Consultation Response from KC, Highways Development Management**2021/91975 Croft House Surgery, 1145, Manchester Road, Slaithwaite, Huddersfield, HD7 5JY****Redevelopment of Croft House Surgery with demolition of existing 2 storey flat roof car port / office building, alterations to existing building to form 5 residential units and erection of 3 dwellings. (within a Conservation Area)****Date Responded: 07/06/21 | Responding Officer: J Turner | Responding Ref: K1-42/25**

This application seeks approval for the redevelopment of Croft House Surgery with demolition of existing 2 storey flat roof car port / office building, alterations to existing building to form 5 residential units and erection of 3 dwellings (within a Conservation Area) at Manchester Road, Slaithwaite.

Proposed Site Plan 1:100

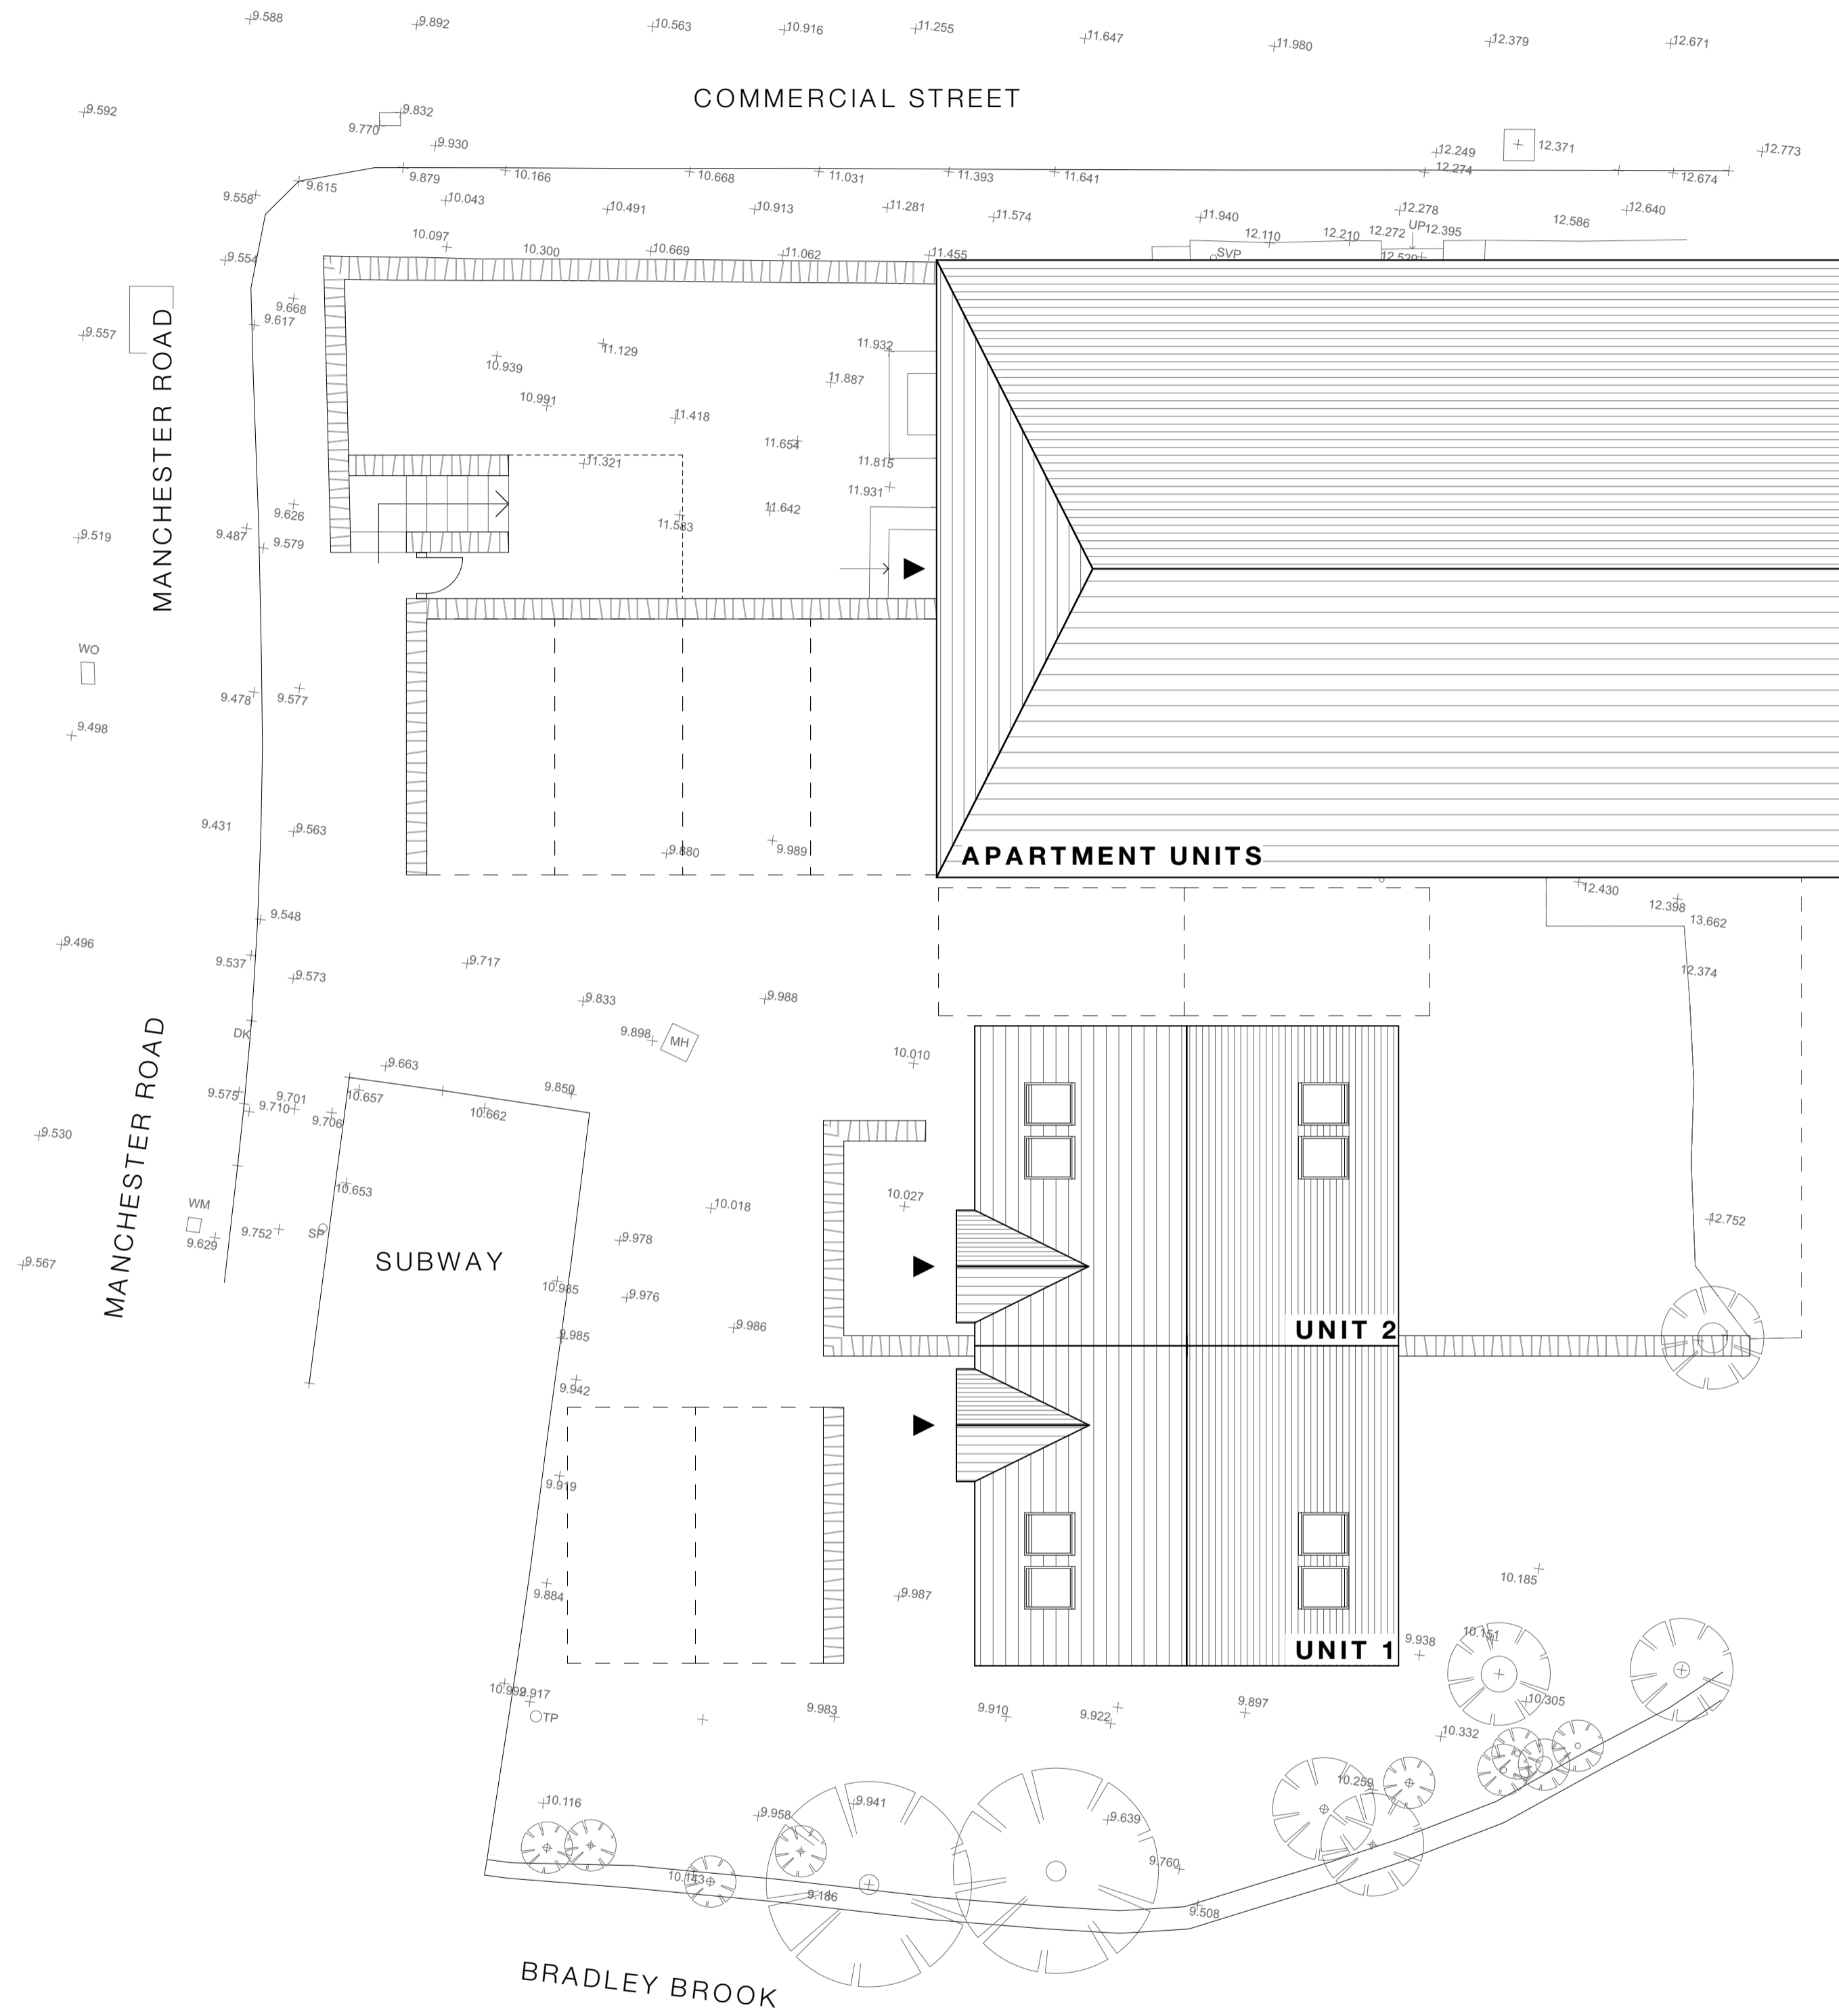
The proposed development would create a six-spaced car park to serve the eight residences. No details of bin storage or collection have been shown. It is accepted that visibility from the access onto Manchester Road will remain unchanged and the vehicular use of this access is likely to decrease. The surgery previously benefitted from an off-street parking on Commercial Street.

Highways DM would expect parking to be in line with the recommendations set out in Kirklees' Highway Design Guide SPD; this equates to two off-street parking spaces for each of the dwellings, another space for each apartment, and visitor parking supplied at a rate of one per four residential properties. The present layout provides six off-street spaces where HDM would anticipate thirteen spaces would be required for a development of this size.

There will be an increase in the number of bins required to service the dwellings compared to the surgery. As such, bin storage pads and a collection points adjacent to the public highway should be demonstrated on a plan.

- Off-street parking in line with the recommendations set out in Kirklees' Highway Design Guide SPD provided.
- Bin storage and collection pads demonstrated on a plan.
